May 22, 2019

Thank you for the review and comments that you provided for the "Weihl Road Improvement" project (SE -19-00007). As the engineering design Consultant under contract with the County, I am responding to your letter on their behalf. Below is a summary of responses to your questions and comments:

Image 1: Photo taken from Red Bridge Road facing north up the ridge, taken January 2009.

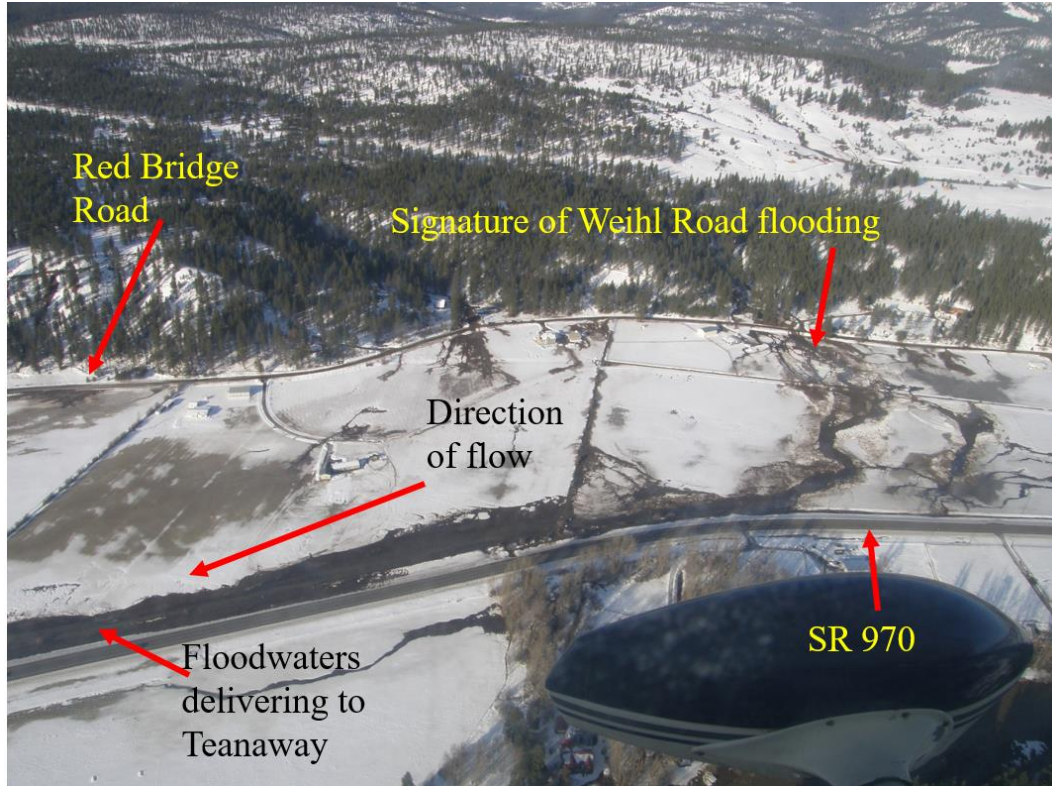
2. WDFW concurs that the installation of the nine culverts shown in the plan set are exempt from Hydraulic Project Approval regulation. However, we would like to offer the recommendation that you consider upsizing all culverts involved, most especially the culverts which run east-west under Weihl Road, as shown on sheet 8-11. On April 29, 2019, the single existing east-west culvert was measured as being 24" diameter. However, plan sheet shows that the new culverts will be 18" CMP pipes, which means that the one existing pipe will be downsized. Although the number of culverts is increasing, WDFW has firsthand knowledge of the hydrology which can flow downhill towards Red Bridge Road (See Images 1-6). This information should be considered when designing and implementing the Weihl Road project.

Response: Thank you for providing the historical hydrology information and photos for this location. We were aware of significant runoff in this area, but we revisited our assumptions as a result of your comment, and have made the following changes to the proposed drainage facilities:

- ***Remove existing 24" east-west culvers near station 3+50 and replace with seven 18" regularly spaced culverts along the project alignment. Revision: Increase to nine 18" regularly spaced culverts.***

- *Provide a new formal ditch on the uphill side (east) of Weihl Road to replace the intermittent and failing existing ditch. **Revision: line ditch with quarry spalls to minimize potential erosion during high flow events.***

- *Replace existing 48" culvert that serves the abandoned irrigation canal at approximate station 0+75 with a new 48" culvert with beveled ends. **Revision: remove existing debris and formalize the ditch upstream and downstream of the new culvert (within the limits of the existing County right of way)***

Image 7: Example schematic of a biotechnical approach to outfall stabilization using cobbles and native shrubs.

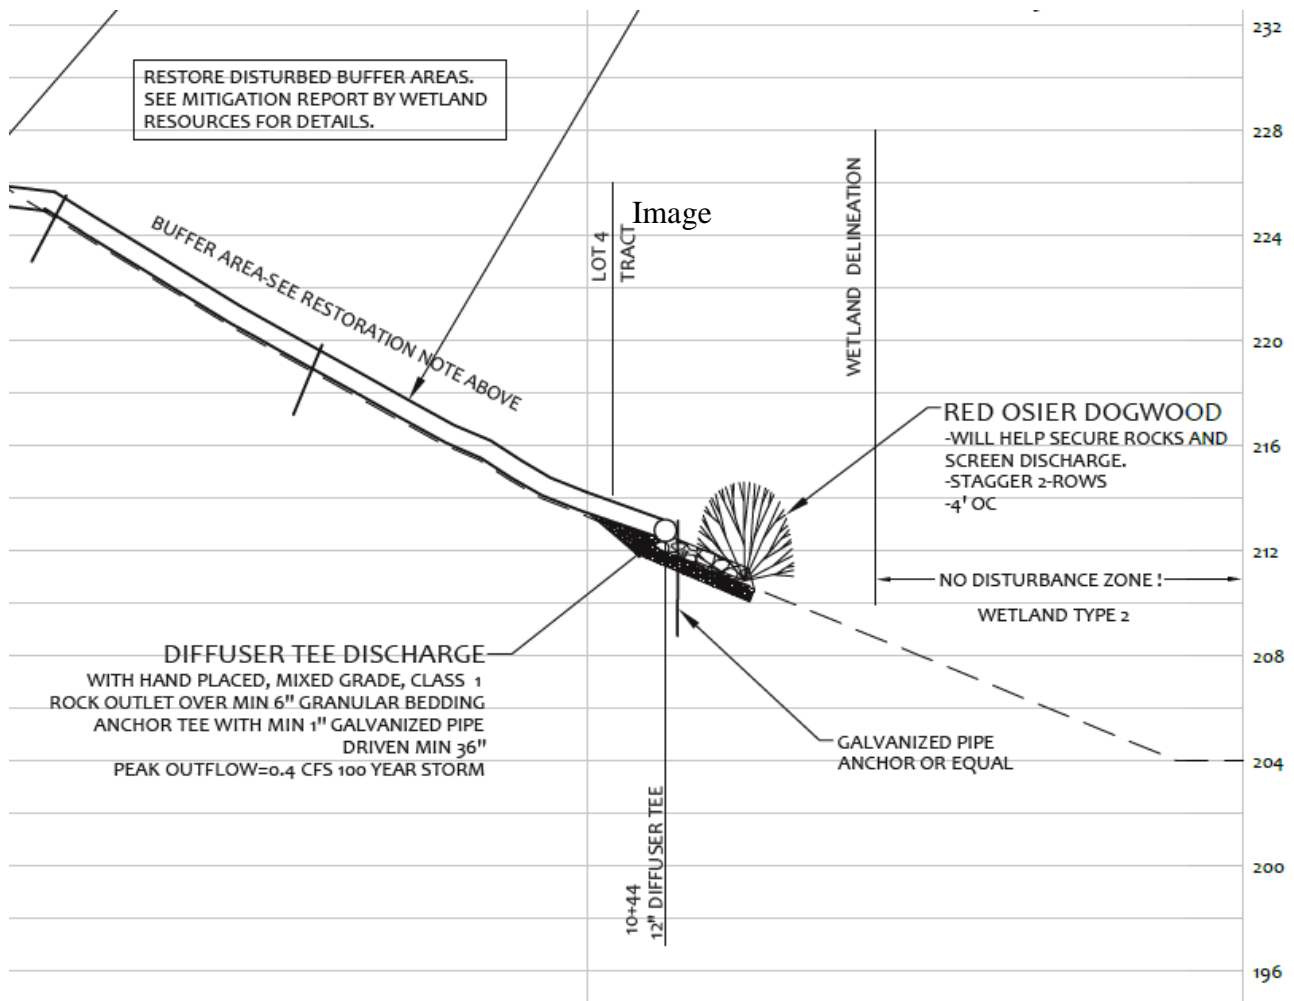
- *Replace existing 8" driveway culvert near station 1+00 with one 18" culvert. **No change.***
3. We recommend that you utilize biotechnical soil stabilization techniques at the base of the east-west culverts where they emerge from the welded wire wall. Then flow which will empty from these culverts has the potential to erode the ground at the base of the proposed wall. On sheet 5, under "Culvert Detail", quarry spalls are shown for placement beneath the installed culverts. However, we recommend placing a geotextile fabric square, covered with rounded cobbles and planted with willow or dogwood stakes, beneath the outfall of the culverts (see Image 7). This technique has been used to great success in preventing erosion on slopes which are subject to overland, non-channelized flow.

Response: In response to comment number three, we have made the following changes to the culvert outfall details:

- ***Revised to add geotextile to the outfall detail as recommended***
- ***Revised to add plantings to further protect the slope and secure the material around the outfall as recommended.***
